**WELWYN HATFIELD BOROUGH COUNCIL
ASSISTANT DIRECTOR (PLANNING)**

DELEGATED APPLICATION

Application No: 6/2019/1101/FULL
Location: Ocado Ltd Gypsy Moth Avenue Hatfield AL10 9BD
Proposal: Erection of an ancillary staff shop following demolition of an existing cabin building
Officer:

Recommendation: Granted

DRAWING TITLE
PROPOSED FLOOR AND ROOF PLANS

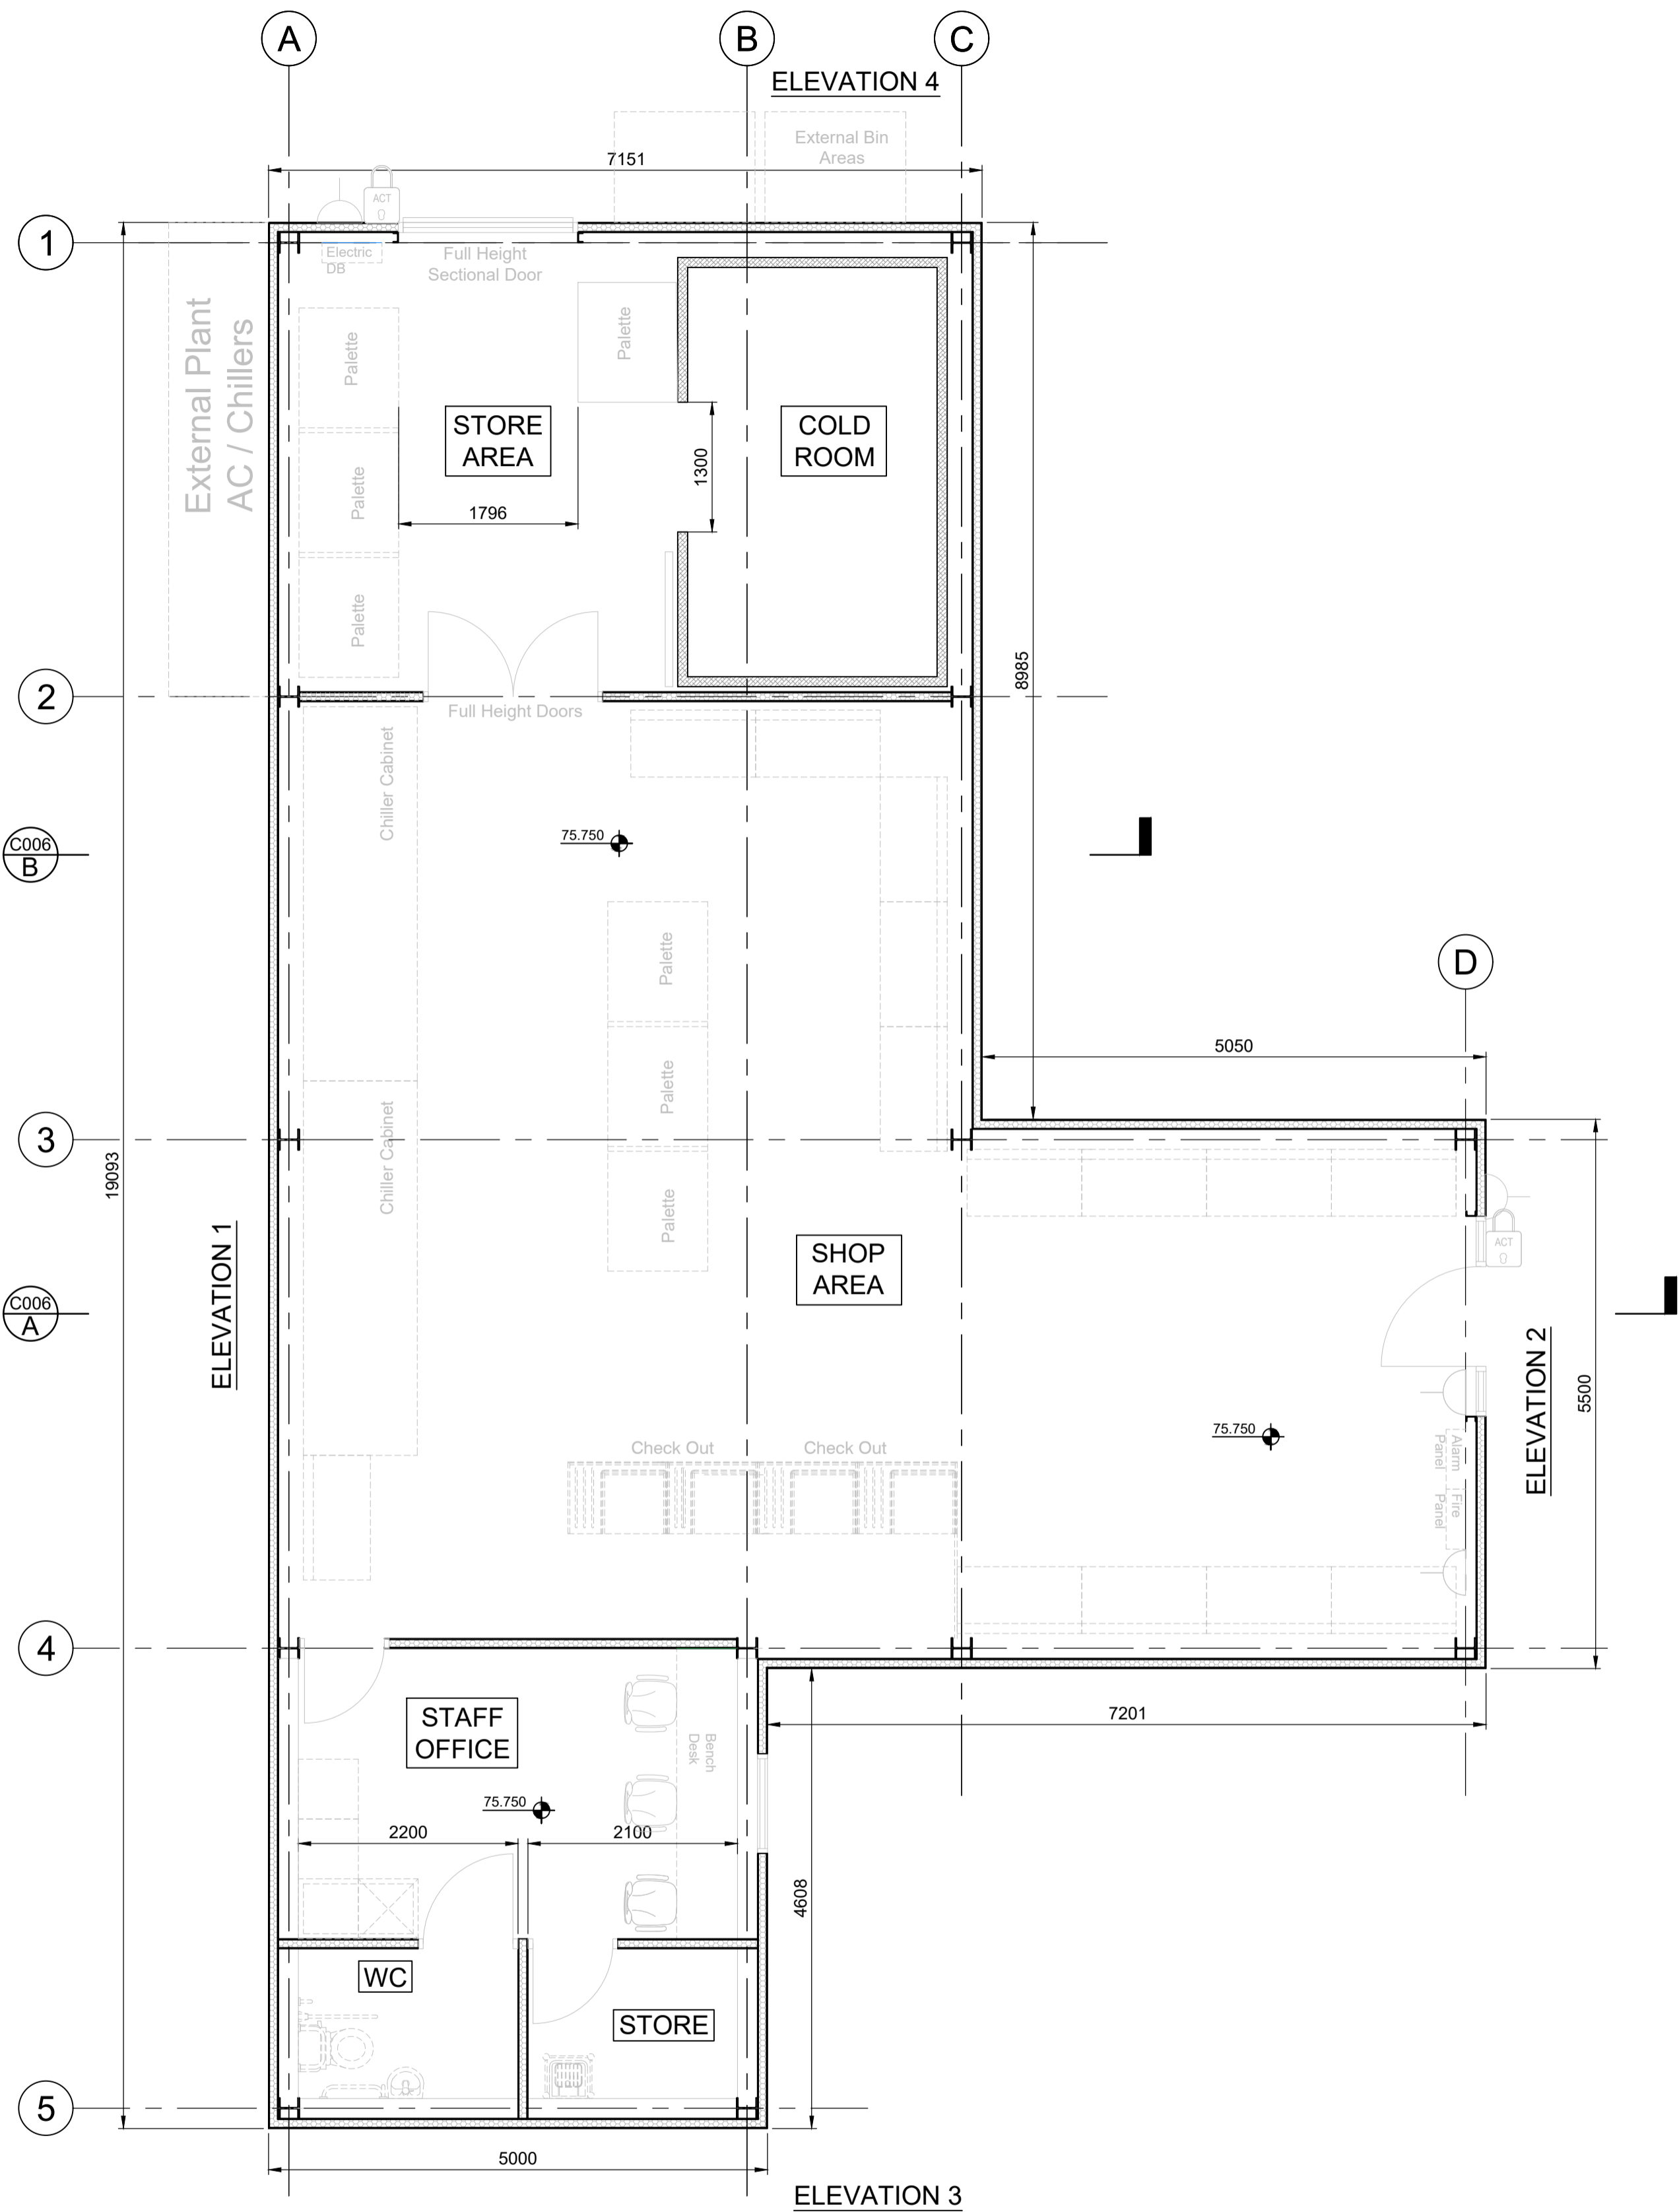
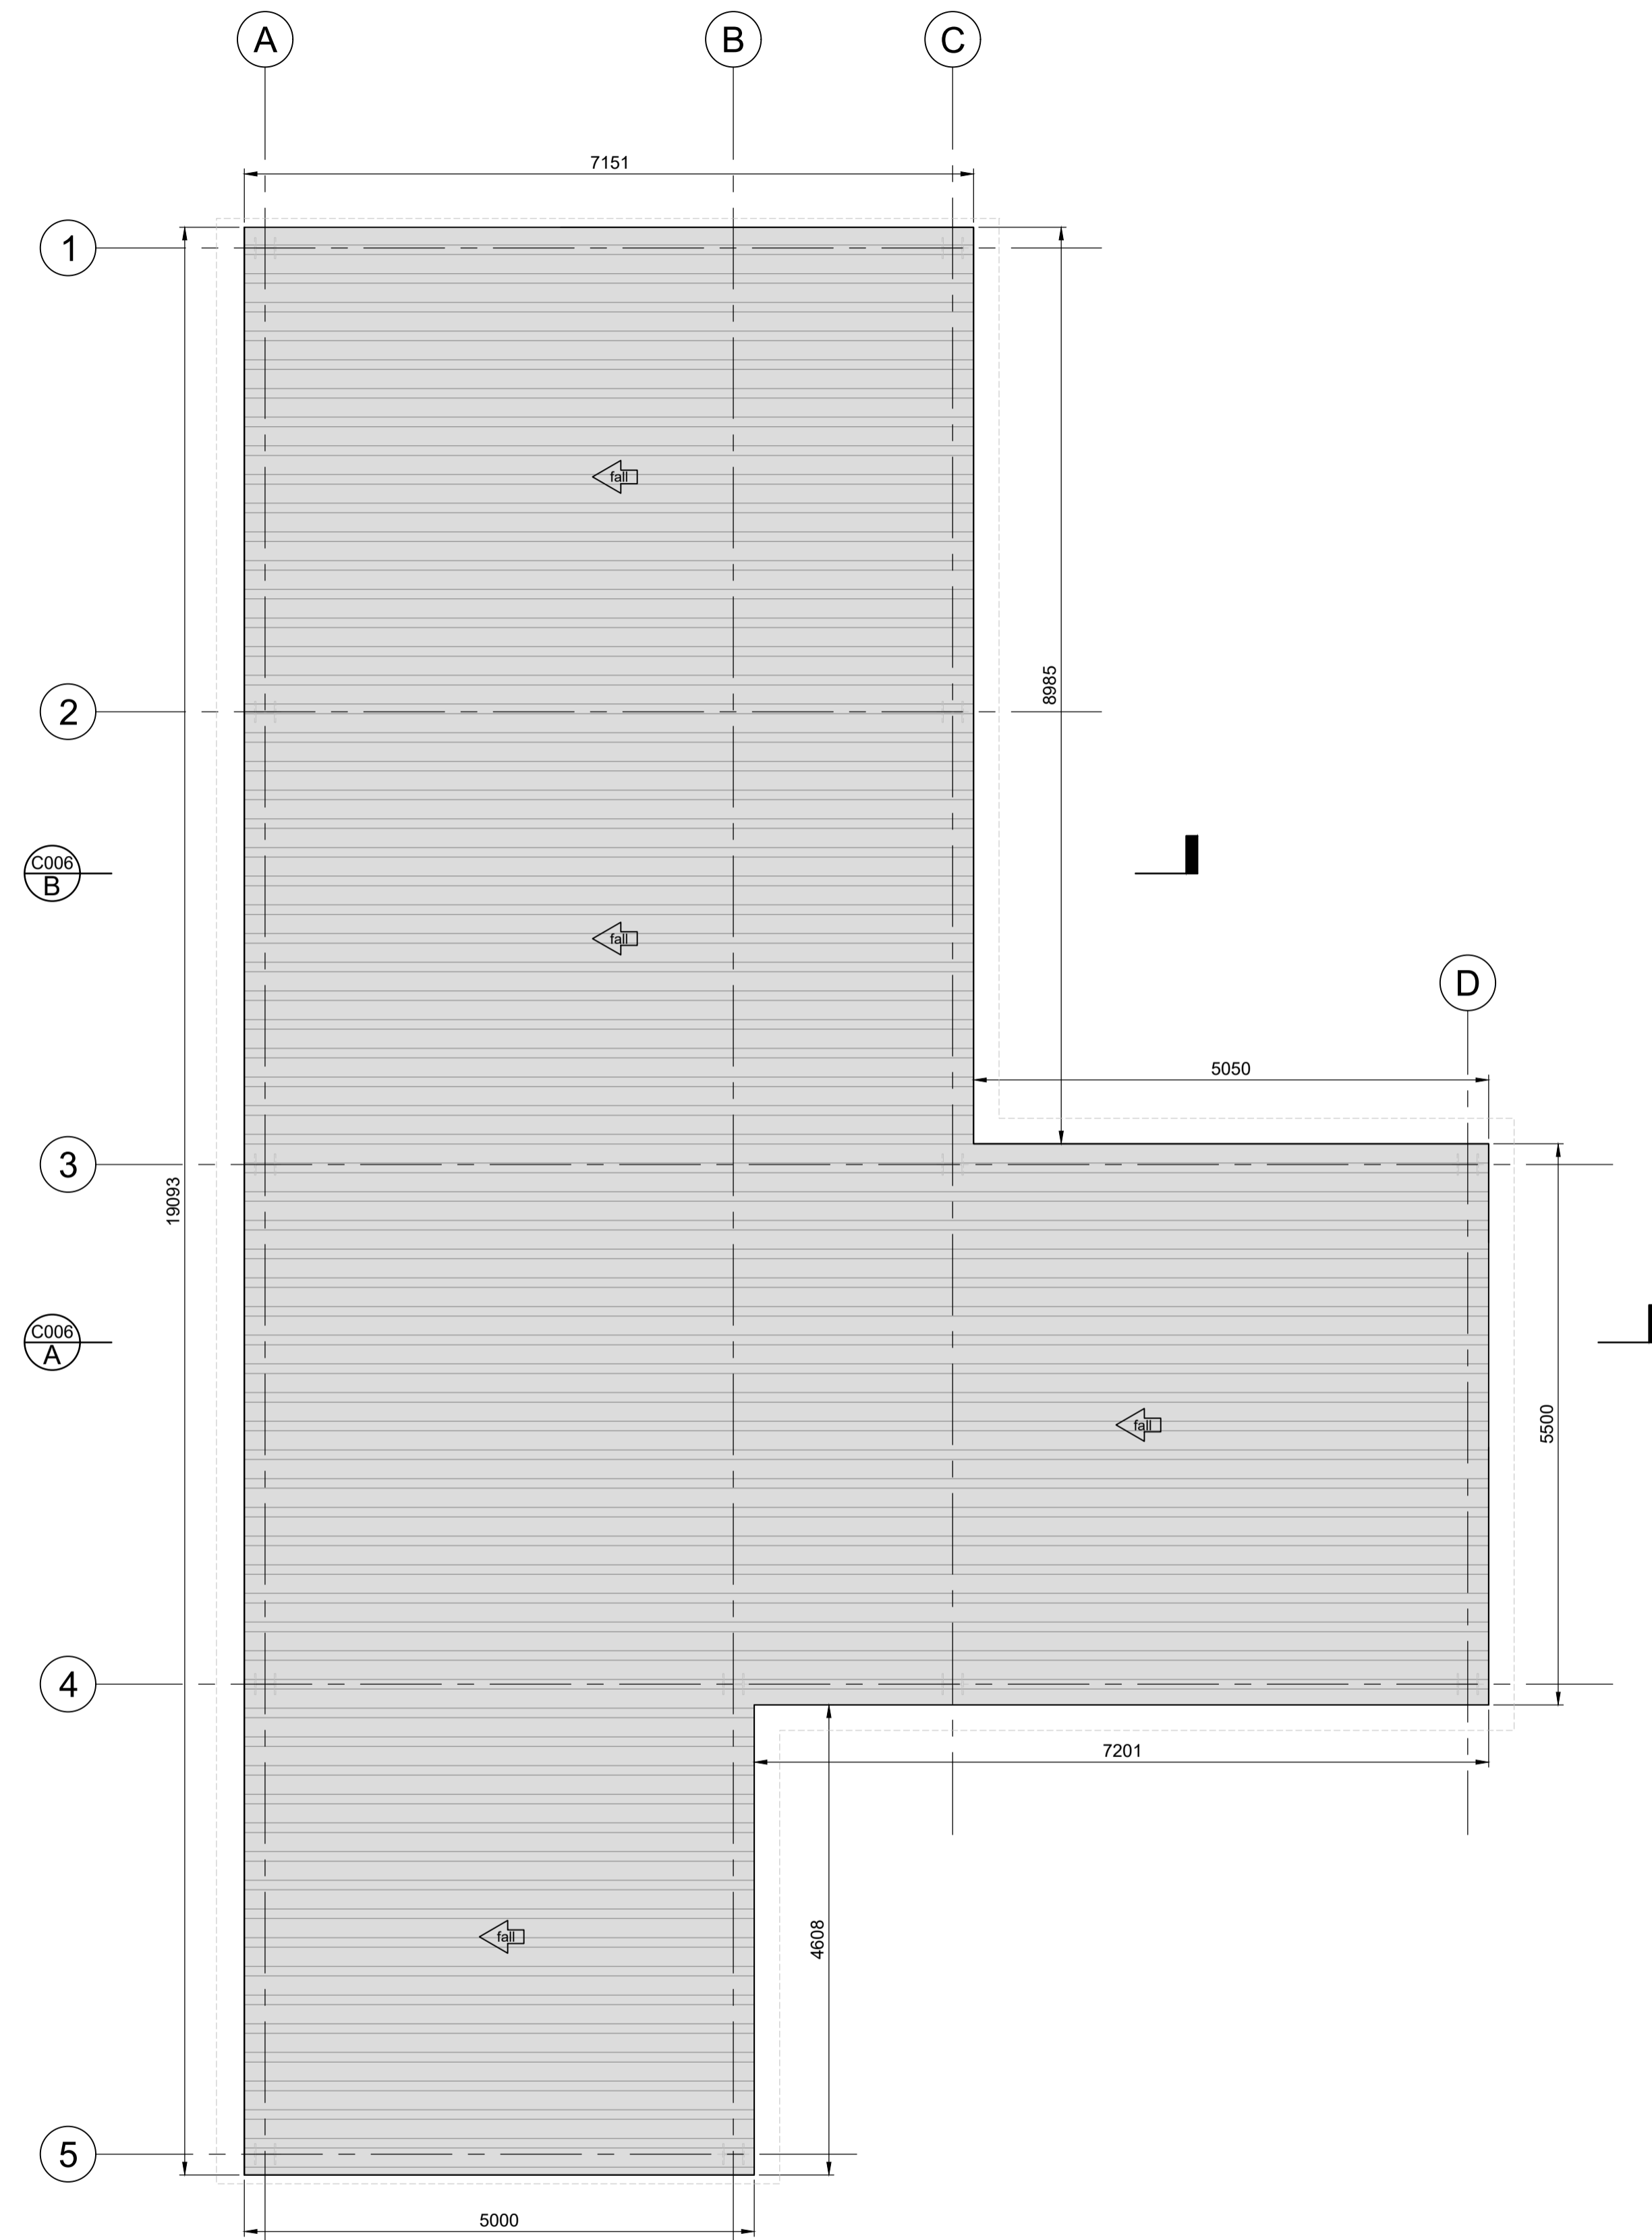
Comment (if applicable): The proposed building is mainly rectangle in shape and has a small projection to the north that is proposed to be used as a shop entrance. The unit would measure approximately 154 sqm located on an area of hard surface. It would have a mono-pitched roof measuring 4.15 metres at its top. The proposed development would be clad with anthracite grey kingspan wall and roof panels.
